SSD-70283710: 1 Crescent Street, Holroyd

Transport Impact Assessment - Response to Submissions

14 November 2025

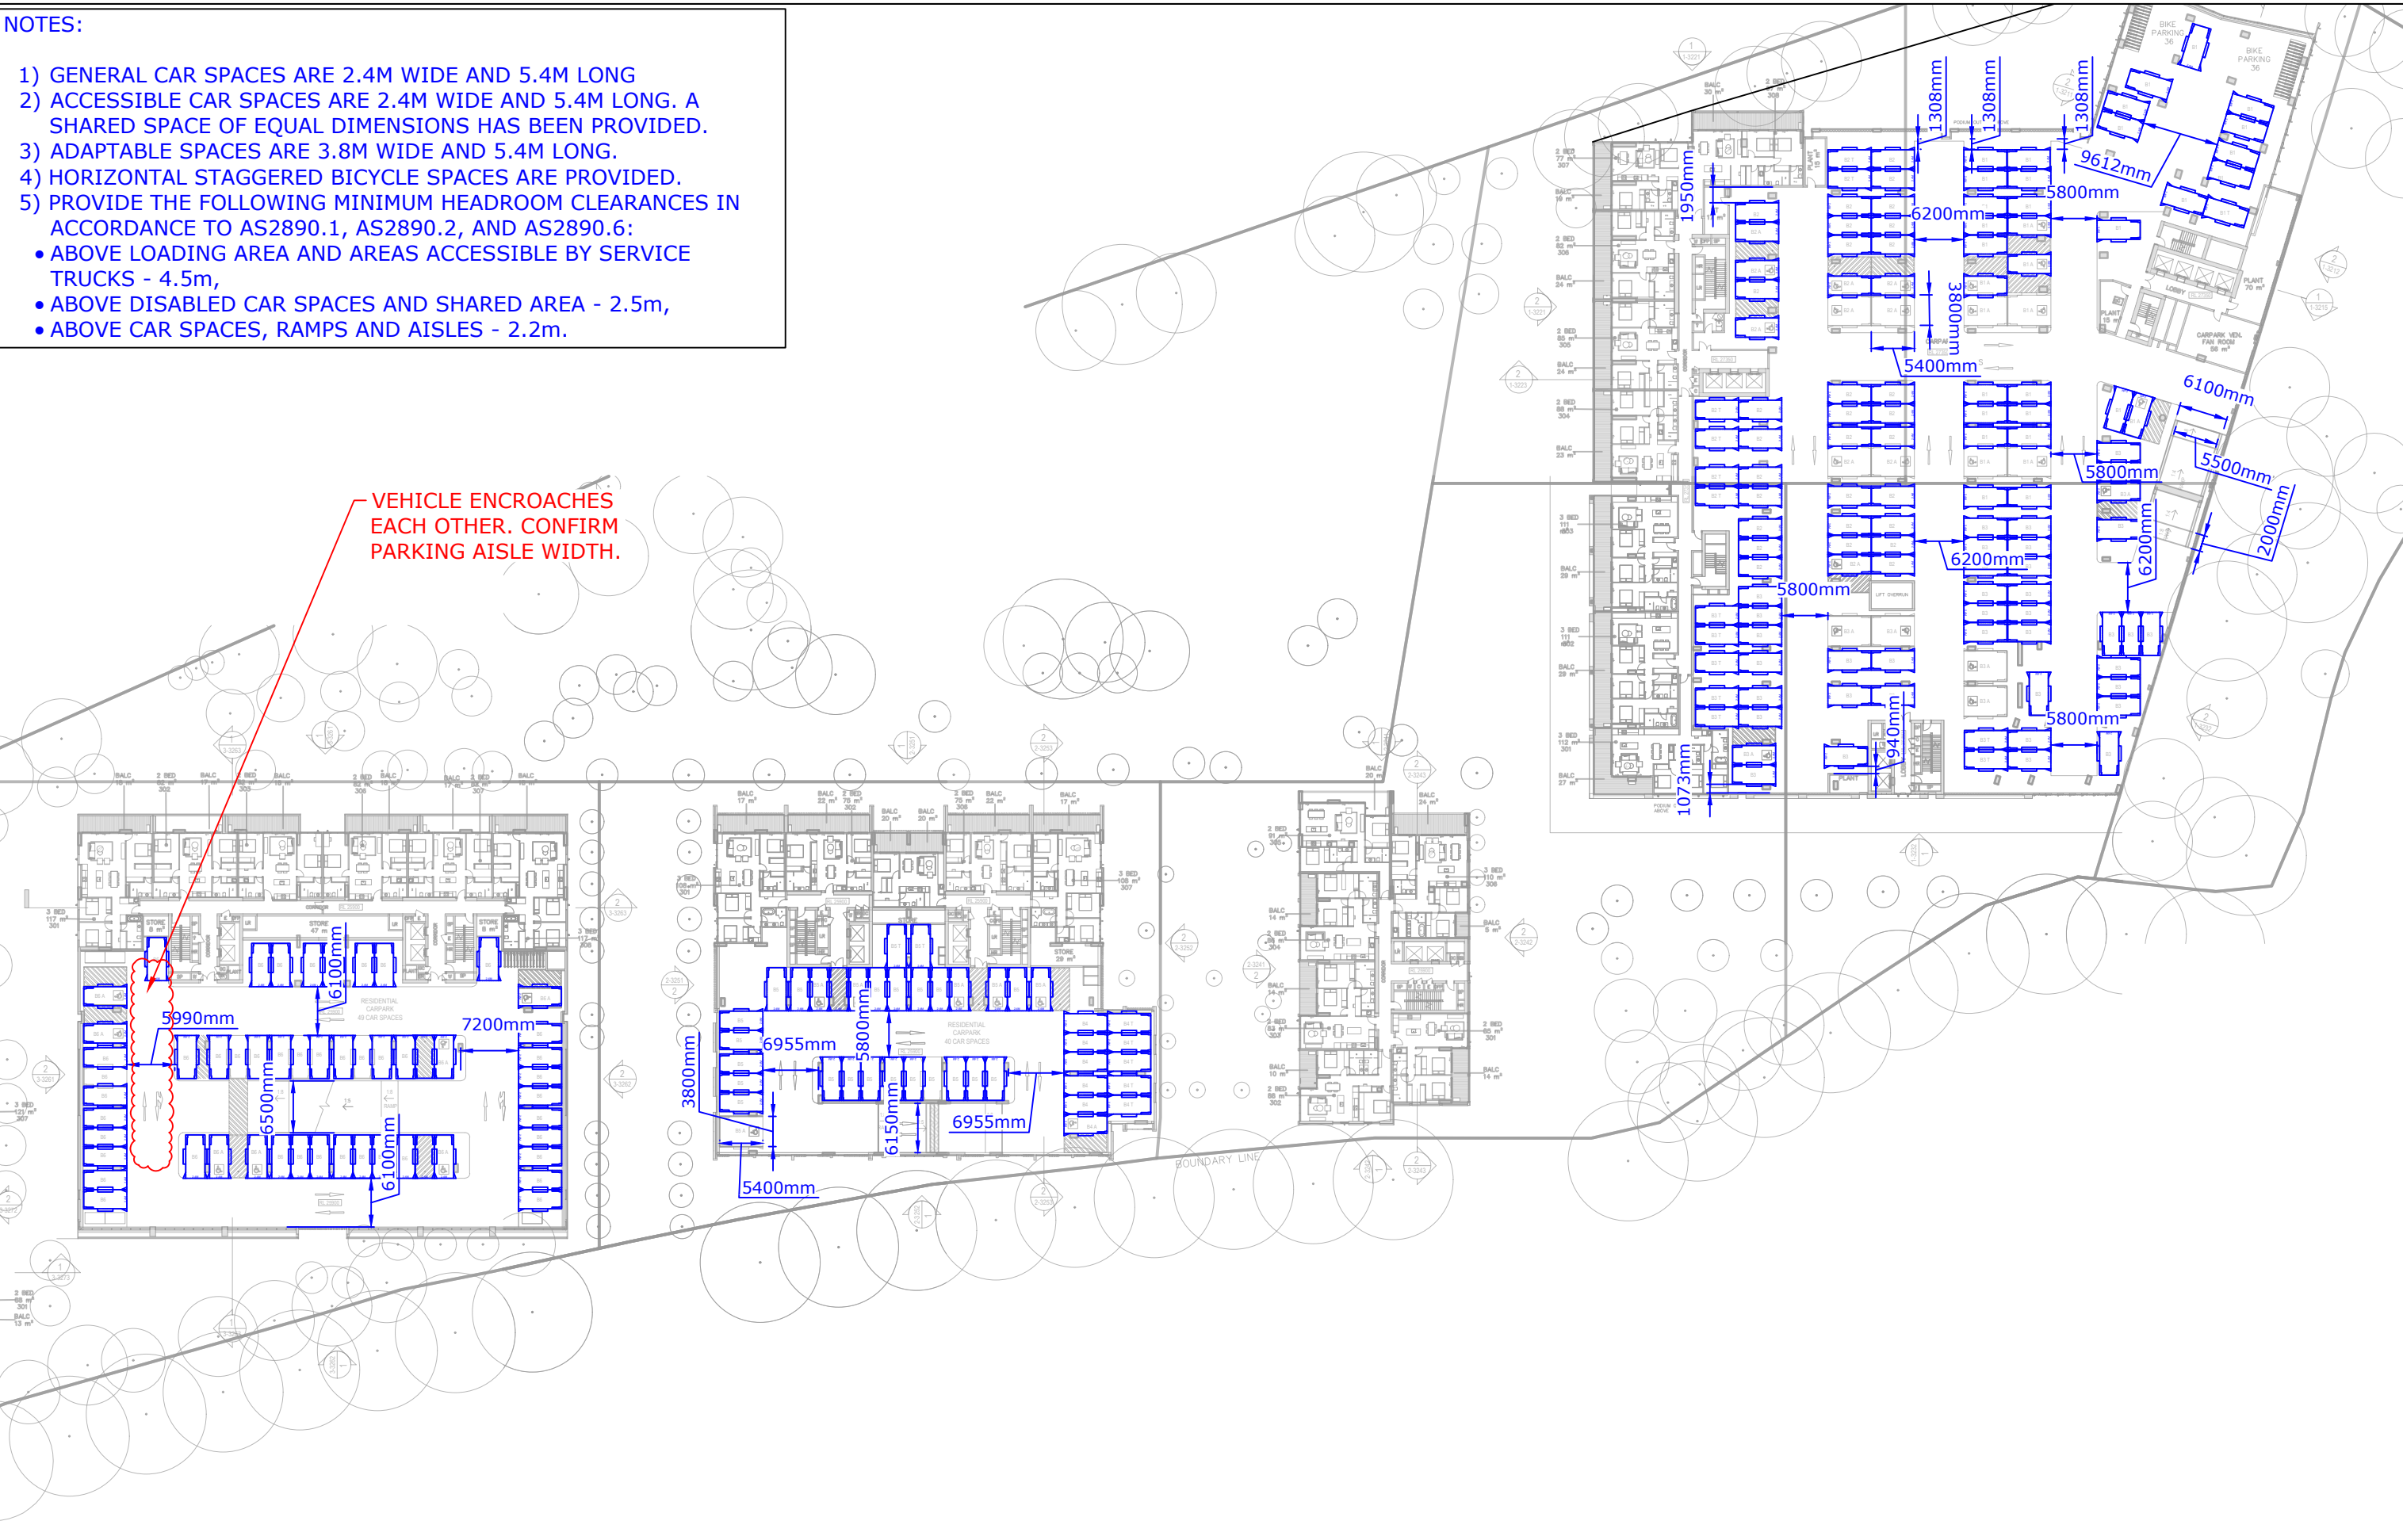
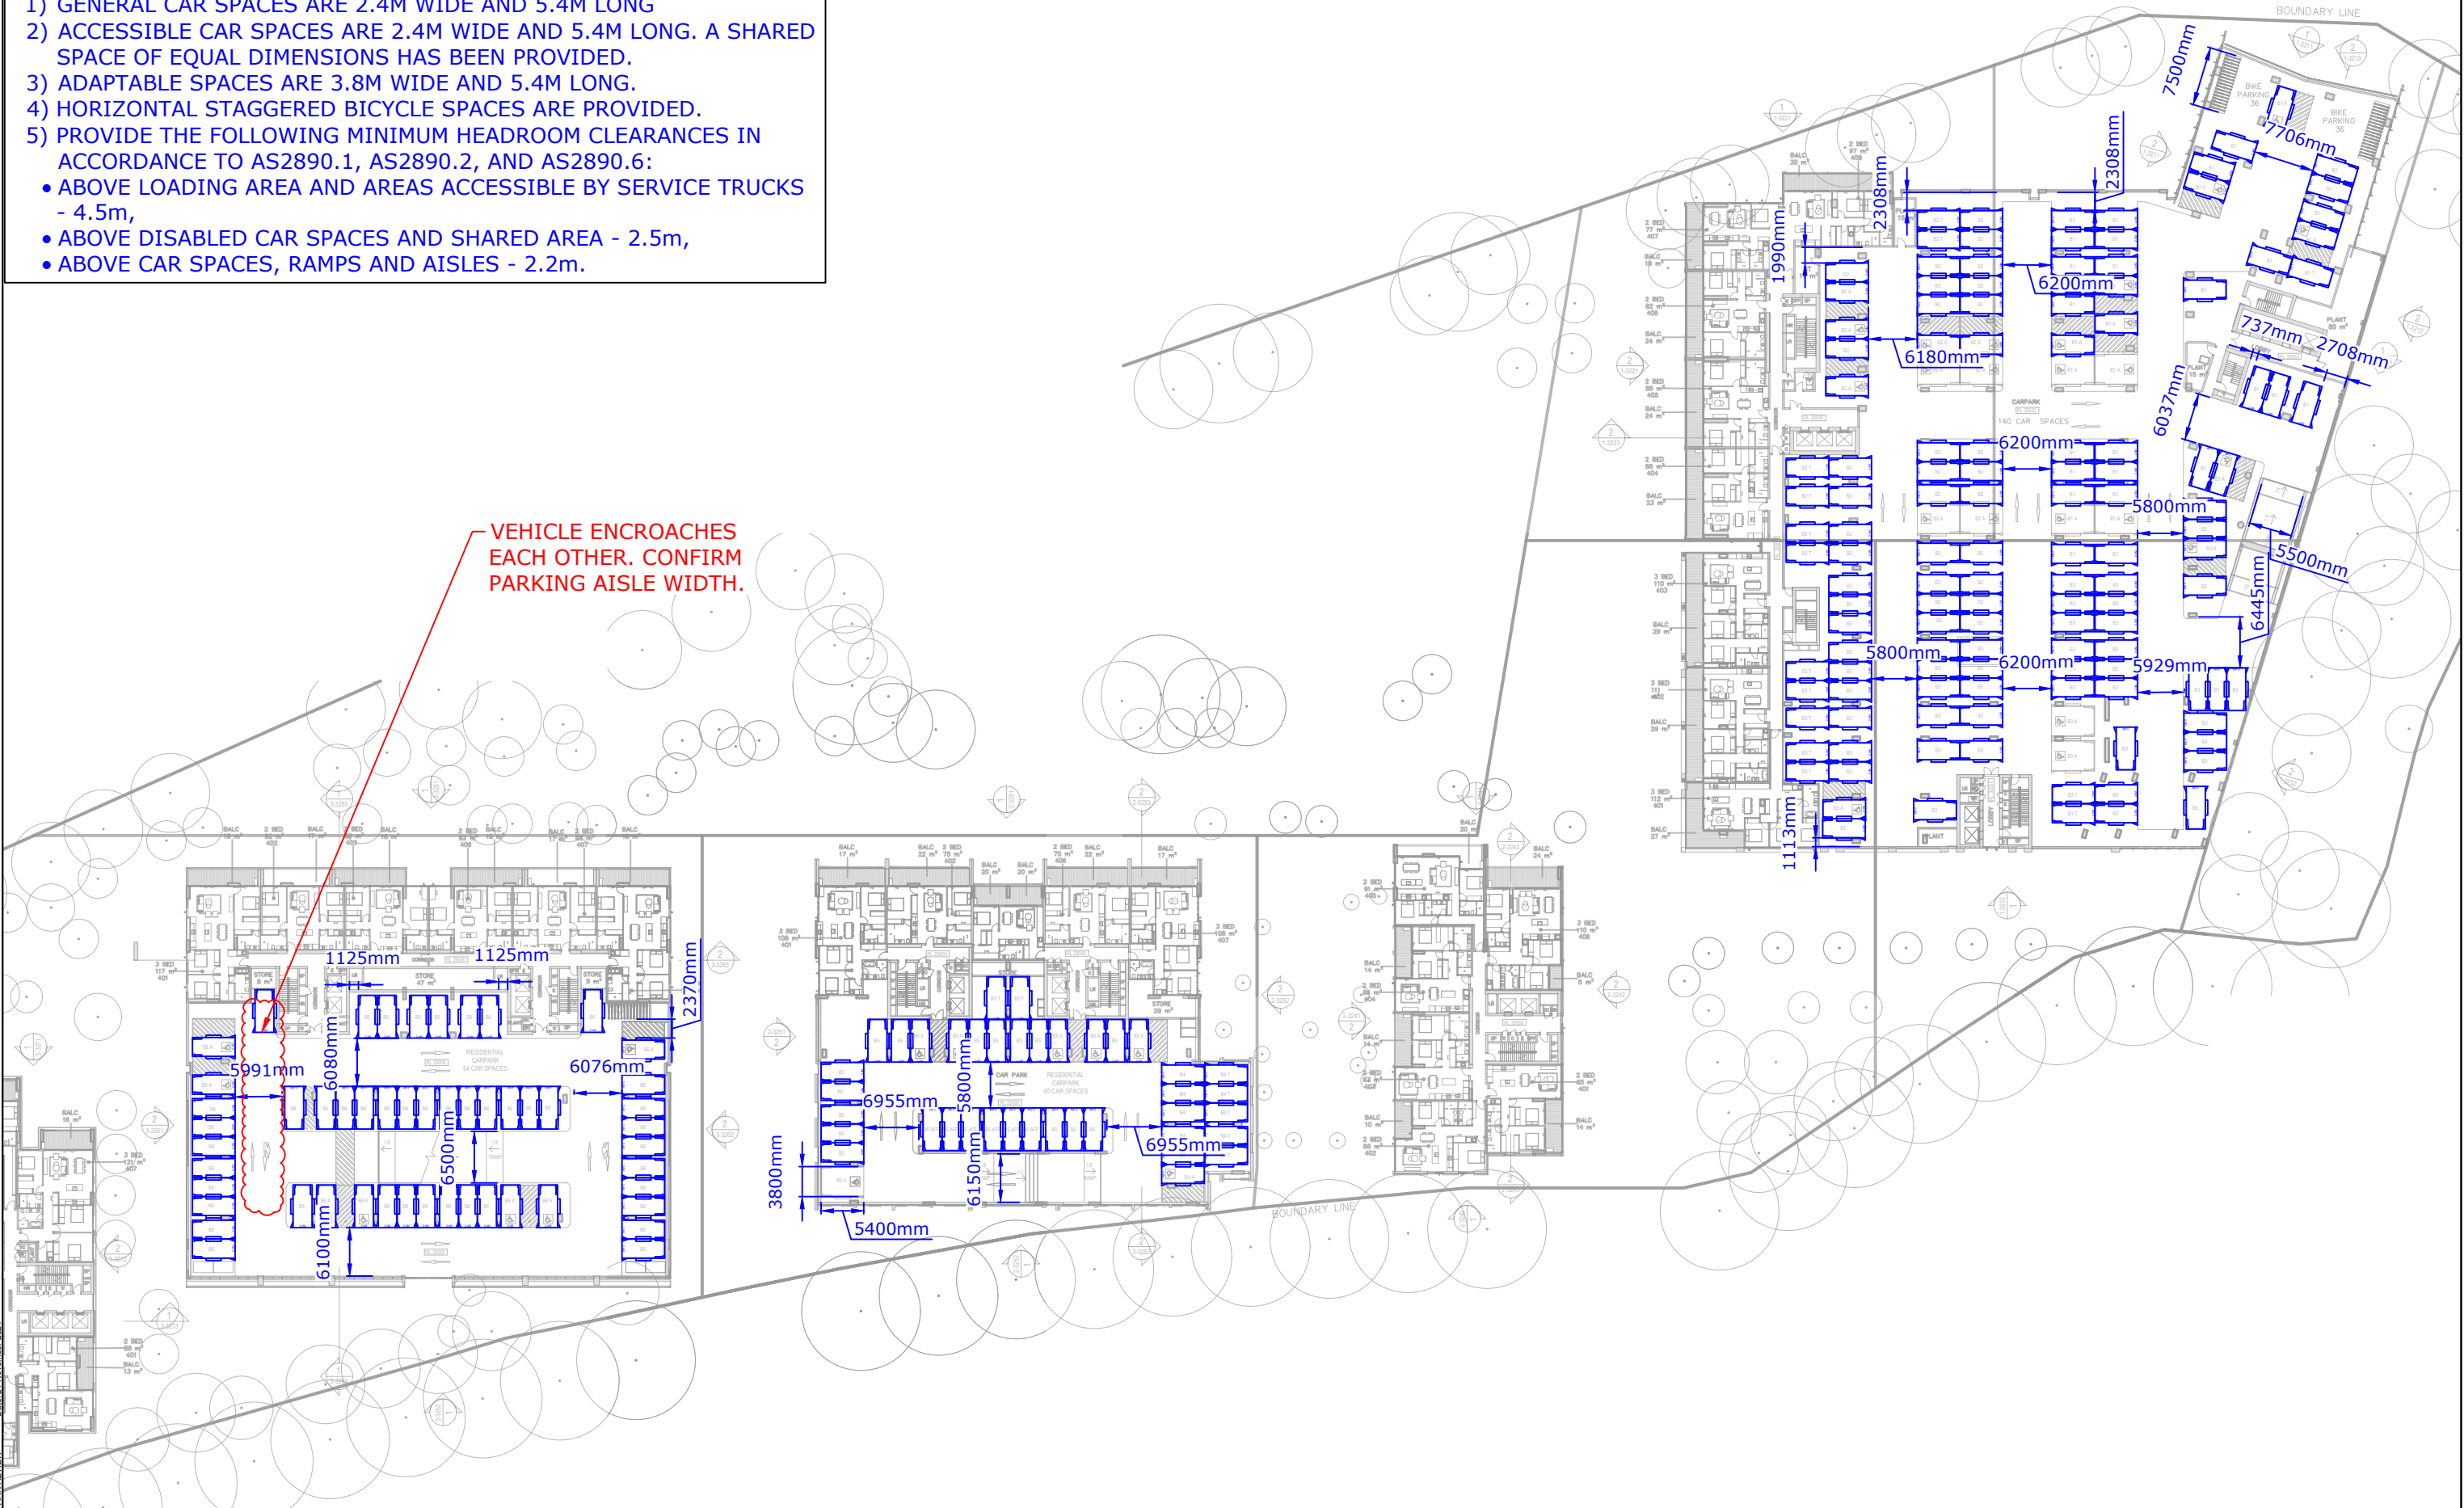
CC-25-1	Parking generally There is an absence of any motor cycle parking which is unrealistic, especially so for considering socio demographics and the number of occupants associated with affordable housing.	Motorcycle parking is not being provided. Potential at CC stage to convert car spaces to motorcycle spaces if required.	Section 5
CC-25-2	Parking generally Each of the parking spaces should be numbered according to the land-use user group for clarity. In addition, parking space provision for each parking level for each Block (phase) should be presented in a tabular form for clarity. The architectural plan of parking area does not provide clarity for review of provision.	The car parking plans have been updated. Parking spaces have been labelled as V for visitor, R for retail, C for commercial and B01, B02, B03 B04 for B05 for residential buildings and CW for car wash bays.	Section 5
CC-25-3	Parking generally The parking spaces and the aisle widths must be dimensioned appropriately for clarity. In addition, the finished floor level must also be shown on the floor plan and at each change of gradient. This includes the finished surface level at each change of gradient along the ramps."	Car park review has included dimensions. Residential aisles are 5.8m wide and 6.2m for retail which comply with AS2890.1. Dimensions of car spaces have been reviewed and checked by TTPP and are attached in Appendix B.	Section 5
